DOC16/474760; EF16/5974

EPA comments on Calga Sand Quarry - Modification 3 (DA 94-4-2004)

The modification proposal before the Department of Planning & Environment (**DPE**) proposes modifying the consent to permit the installation and operation of a crushing system and variation of noise criteria for the project.

Hanson has submitted an Environmental Assessment (**EA**) accompanying the proposal dated August 2016. This EA is accompanied by a Noise Impact Assessment (**NIA**) dated December 2015.

Figure 2 Stage 3 Approved Operations - Source Location

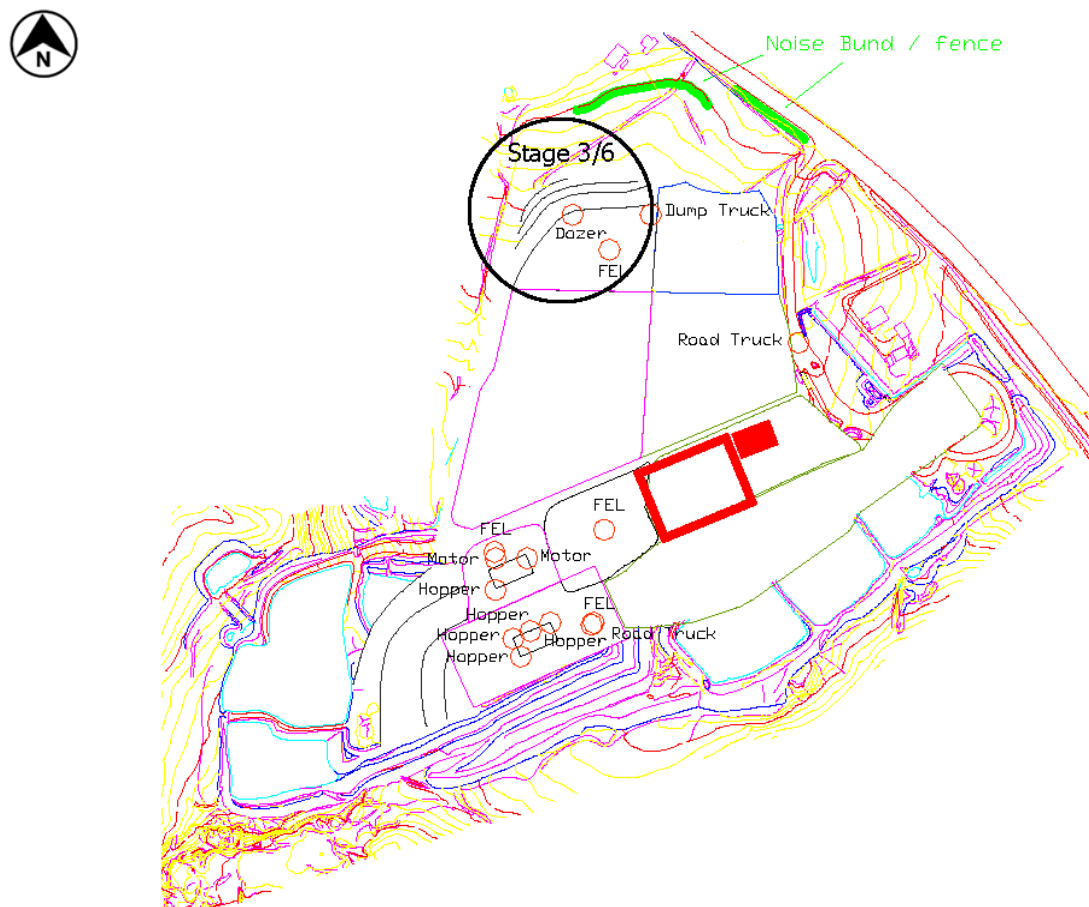
Predicted Noise Level Modelling Methodology – Modelled scenario

Table 1 of the 2015 NIA presents 'Daytime Predicted Noise Levels' for 9 identified receivers. The NIA explains that the existing environmental noise model that was used as part of the 2009 NIA for the southern extension was used for the modelling.

The NIA explains that the predicted noise levels have been modelled based on the '*worst-case season during the daytime period 7.00am-6.00pm in relation to Stage 3 activities when levels are predicted to be higher than 35dBA.*'

The EPA considers that the NIA does not provide sufficient information regarding what scenario was modelled, including what quarrying activities were modelled, what meteorological conditions were modelled and which extraction areas in Stage 3 were assessed during the modelled scenario. This information needs to be provided for the EPA to make a determination on the adequacy of the assessment.

Figure 3 Quarry Operational Areas during Trial Monitoring Period

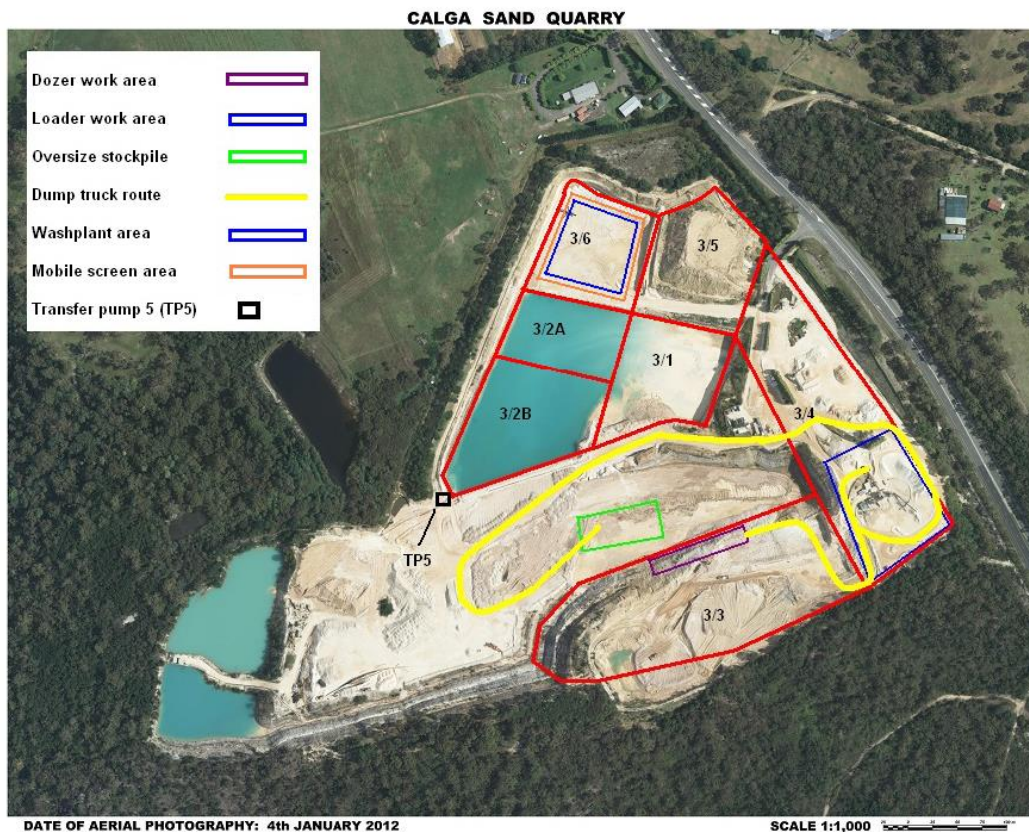
The NIA explains that noise impacts from a mobile crushing plant was tested during a trial of the mobile crushing system at the quarry on 4 March 2013. The NIA explains that attended monitoring was undertaken at receivers CN1 and CN2 to establish whether noise generated by the crusher would be audible amongst the rest of the operations. The NIA notes that the additional noise impact of the crusher was not audible among other operations. The NIA does not however detail the noise results recorded during the attended noise monitoring, what activities were occurring at the quarry during the attended noise monitoring or the meteorological conditions experienced during the attended noise monitoring. This information needs to be provided for the EPA to make a determination on the adequacy of the assessment.
